**From:** Daniel Sellar [REDACTED]  
**Sent:** 17 November 2014 13:02  
**To:** Anita Gardner  
**Subject:** R/243/14/PL - Proposed Development at 69 Broadmark Lane, Rustington

I am writing to you with regard to the above planning application. We have been in dialogue with the developer, Mr Peter Leech for a number of weeks. Below is a record of those emails. As a result of this dialogue he has agreed to undertake a number of revisions to his scheme. In terms of planning matters, the main concerns to us are the following:

Drawing 3
Proposed Elevations

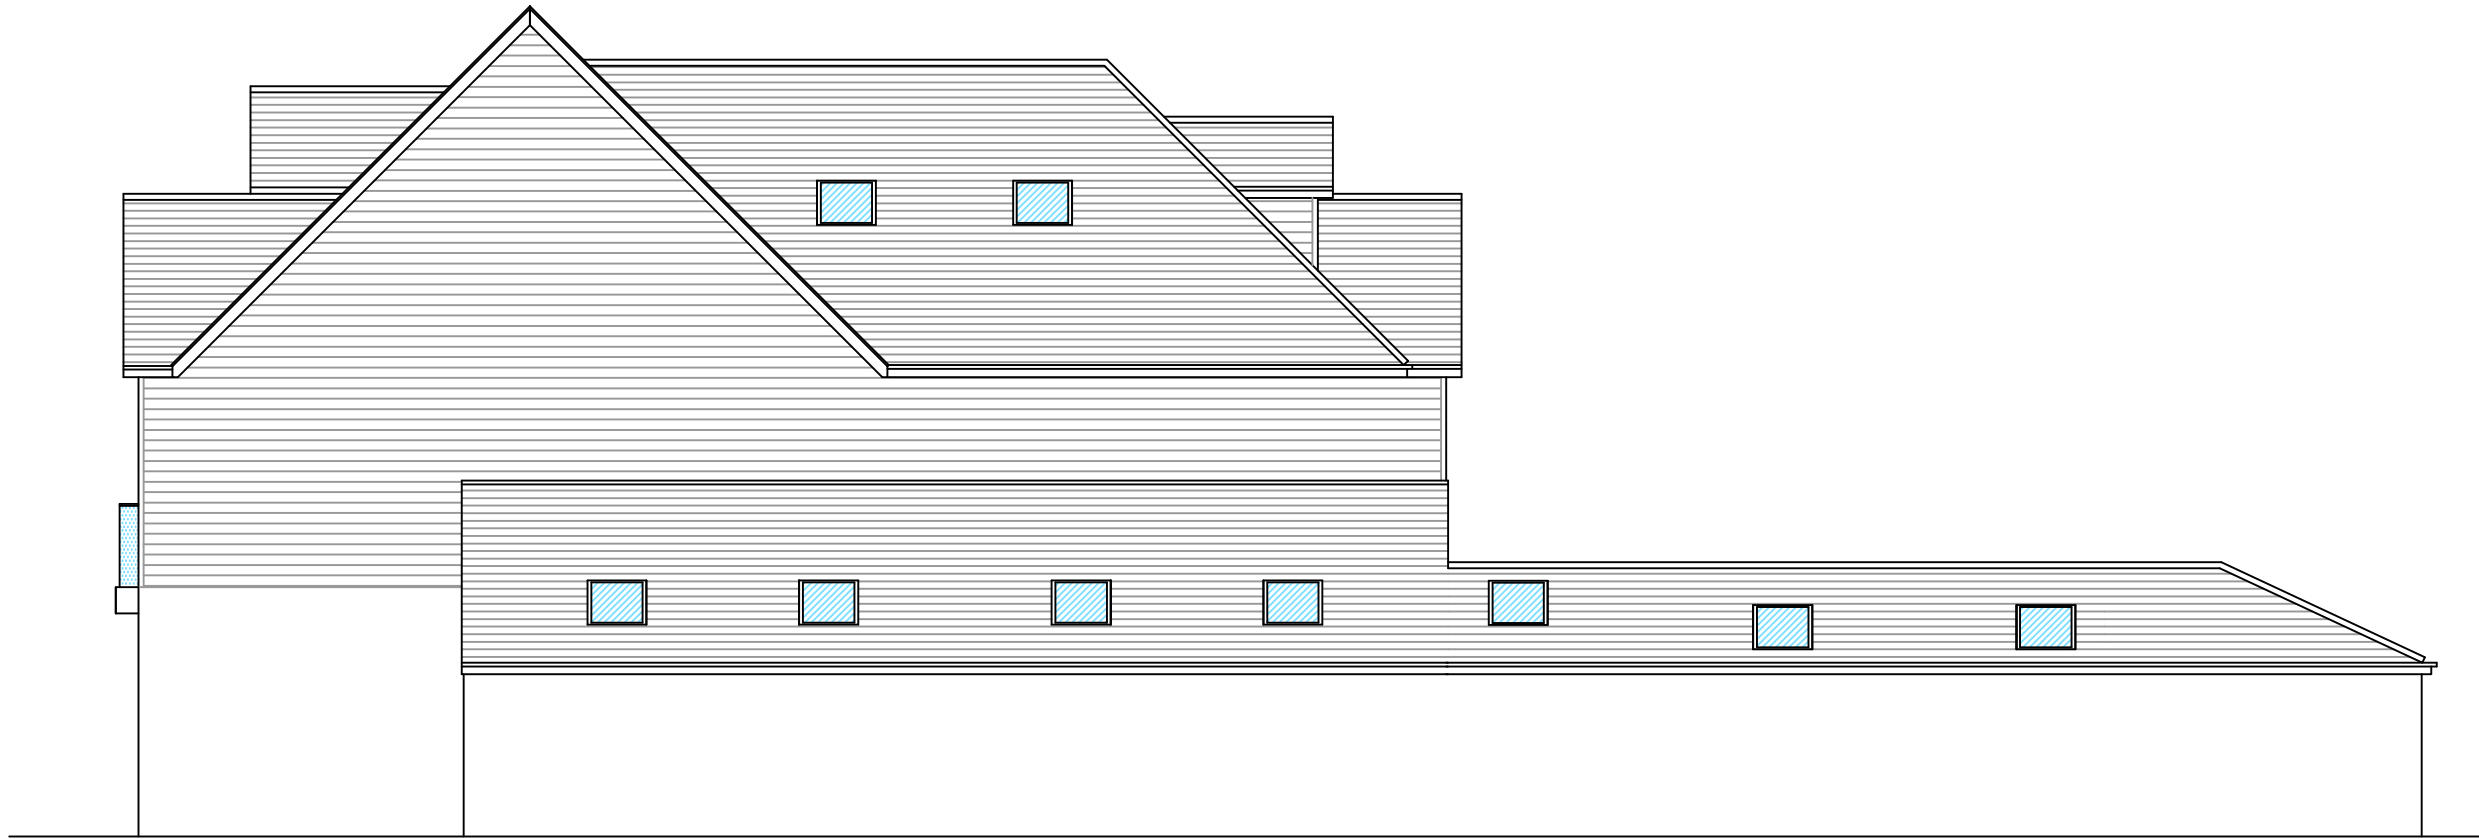
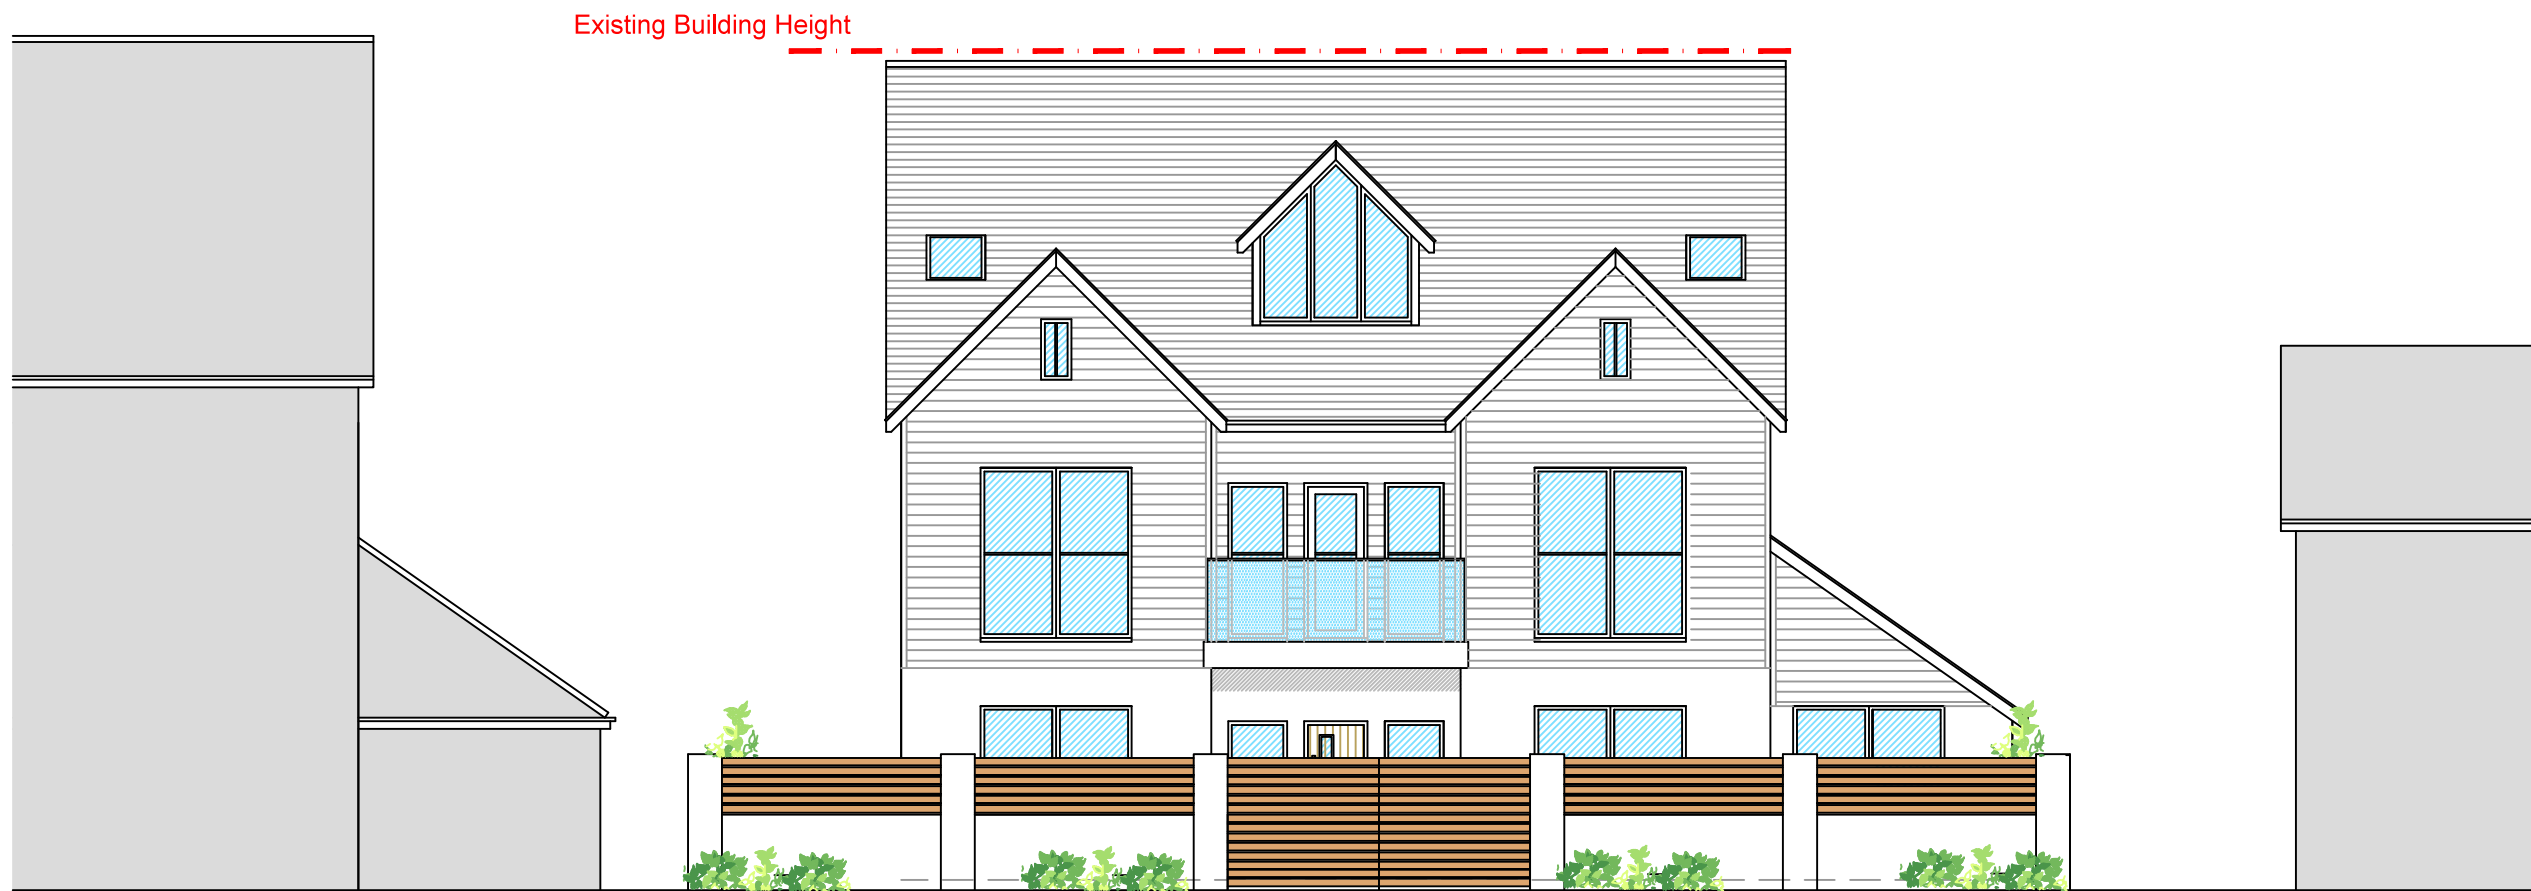
- \* The overlooking from the roof terrace
- \* Noise from the apartment entrances on the north elevation
- \* Protection of our southern boundary wall, hedgerow and fencing during demolition, construction and the completed development
- \* Noise dust and vibration during demolition and construction

1. Regarding the roof terrace. We appreciate the measures you are taking to reduce the impact of overlooking. Having a 1.95m high opaque permanent edge detail surrounding the terrace will certainly help alleviate the issue. Great and I will ensure there are no overlooking issues to the property.

As discussed, please email your detailed plans for the roof terrace, showing the measures you intend to employ to protect our privacy. As you know my mother is understandably very concerned about this.

- \* Making the roof terrace walls at least 1.95m high and opaque so as to prevent overlooking.
- \* Agreeing to use hard landscaping and soft closing hinges on the north elevation to prevent noise from the comings and goings of residents.
- \* Including our boundary wall and associated hedgerow and fencing in a condition survey
- \* Providing a contractors method statement
